Re Architectural Design Statement - Response to SSD submissions

Further to the receipt of the submissions to the SSD for Shore Physical Education Centre we have the following responses.

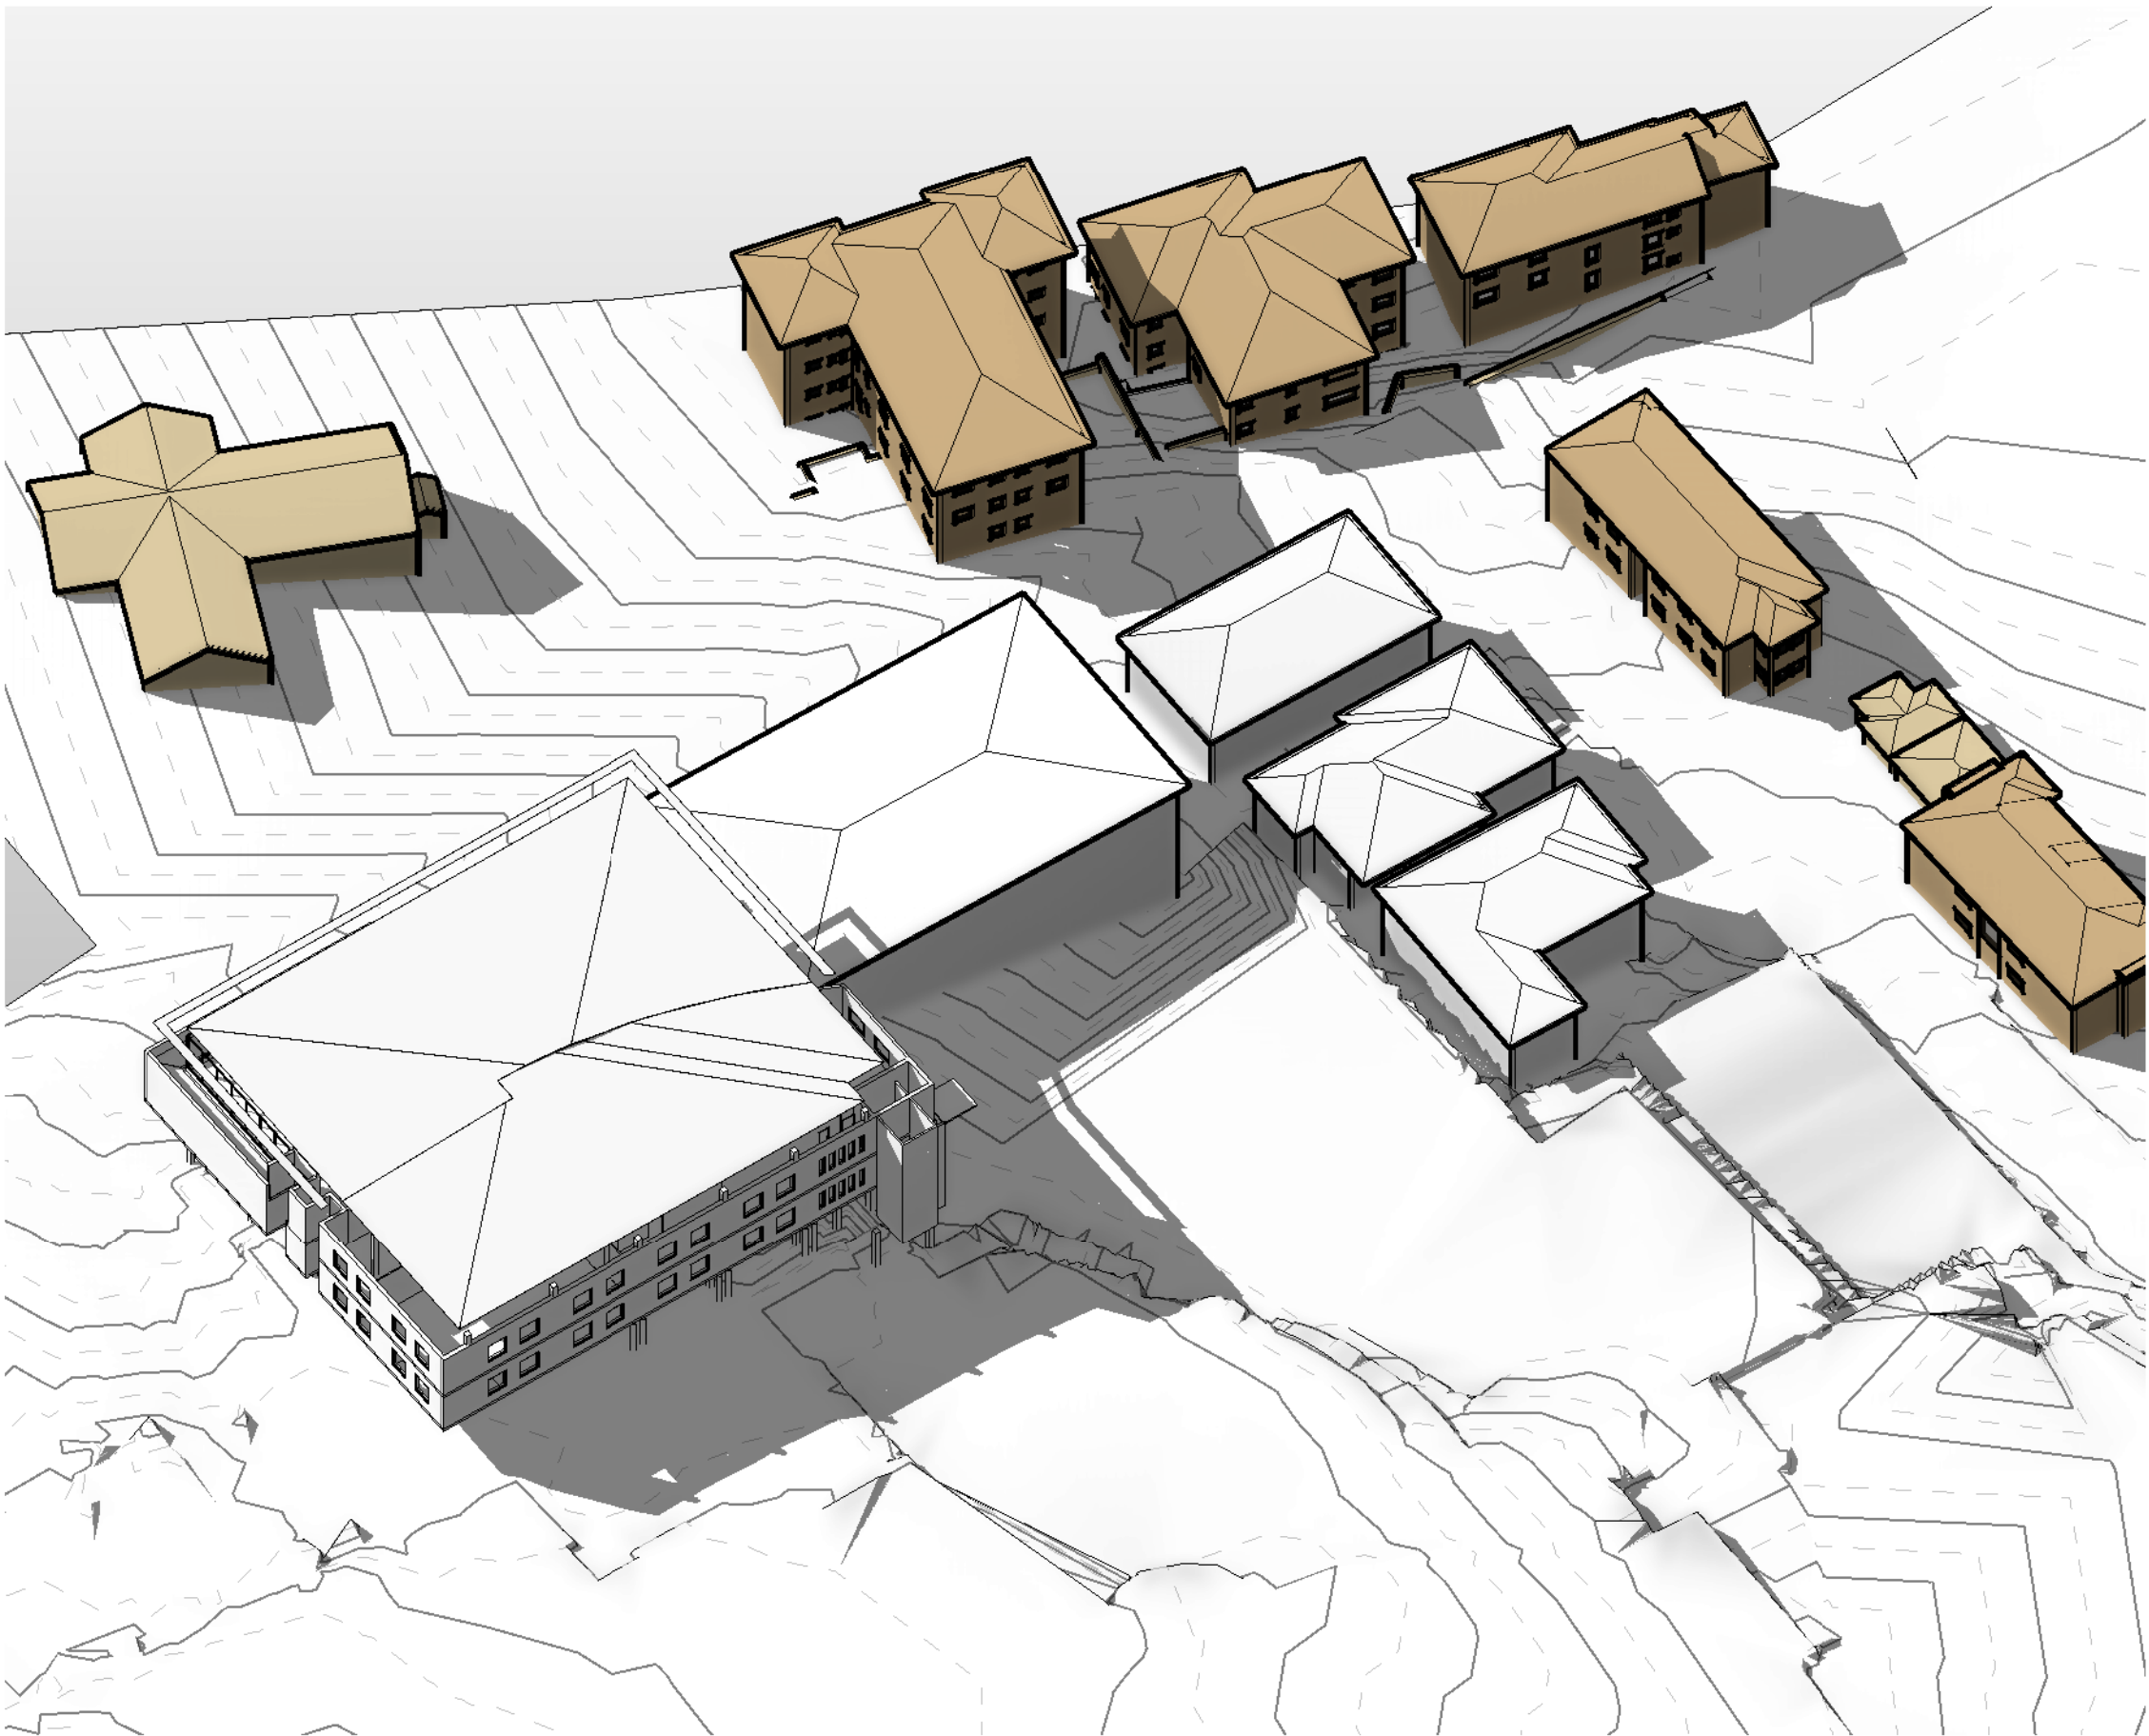
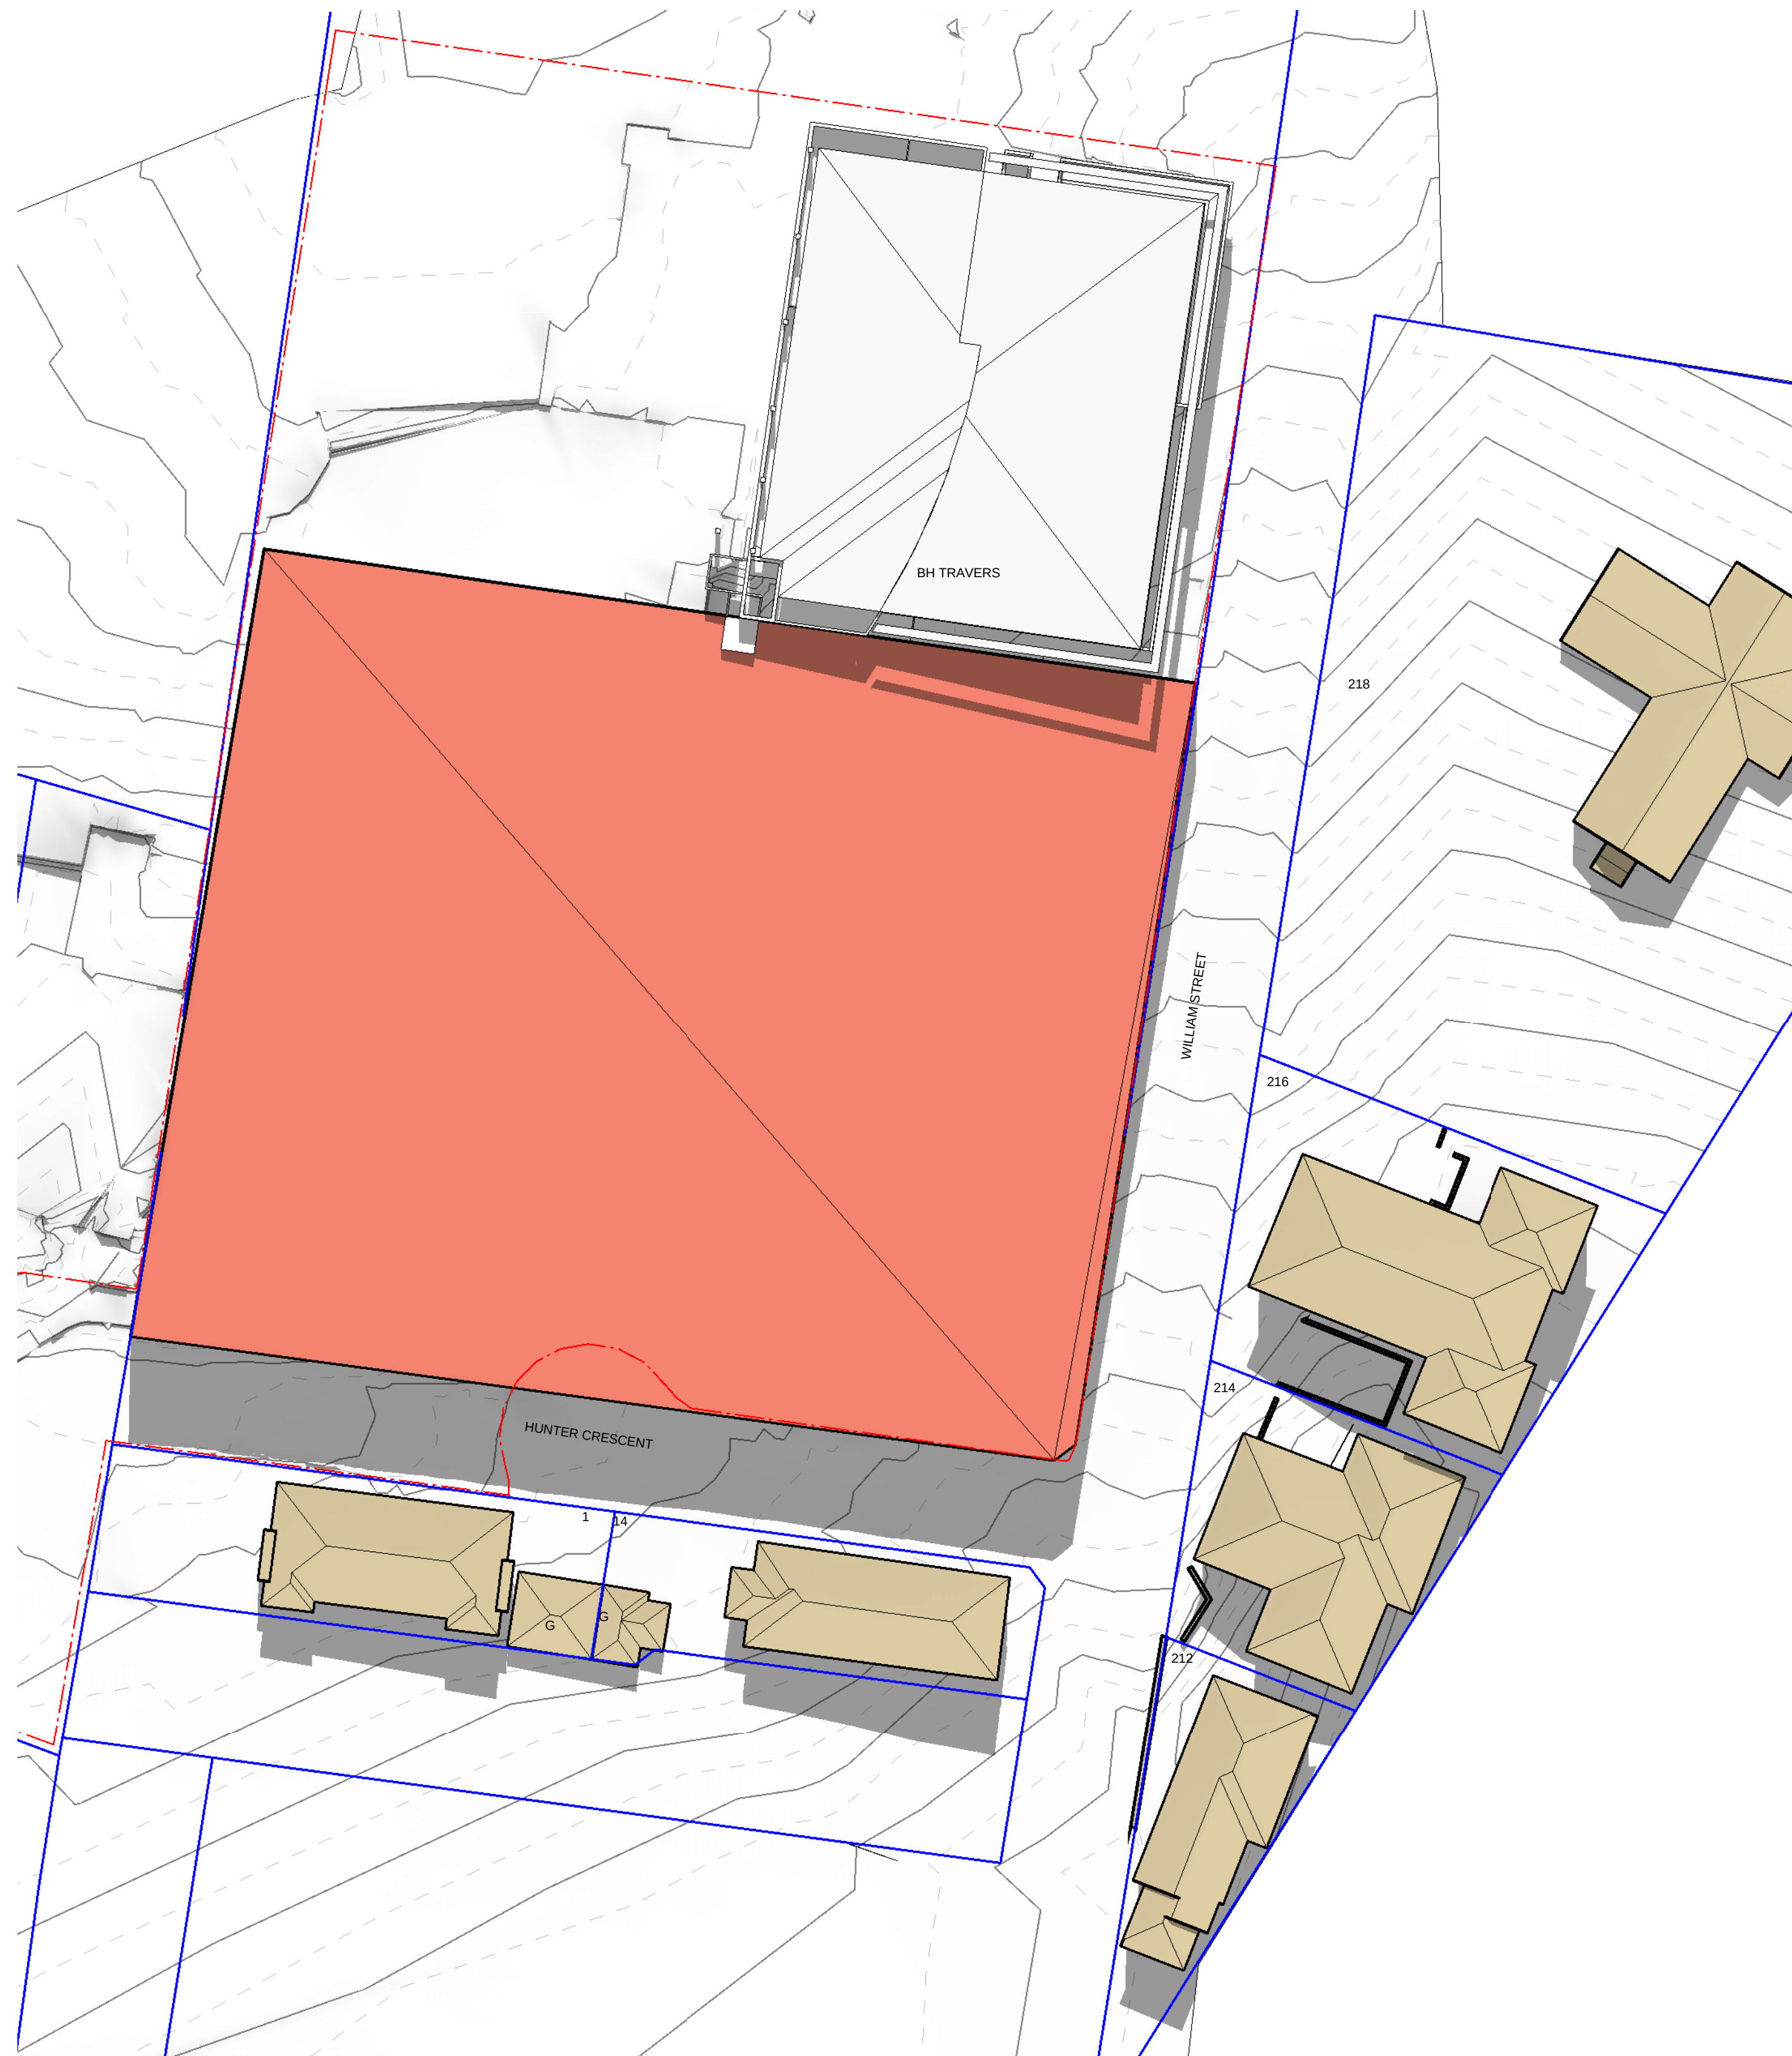
The shadow diagrams provided in the SSD submission provide evidence of the windows to habitable rooms that are impacted by overshadowing, with a comparison with those of a compliant height development. There is little difference between the compliant height development shadows and the proposed SPEC.
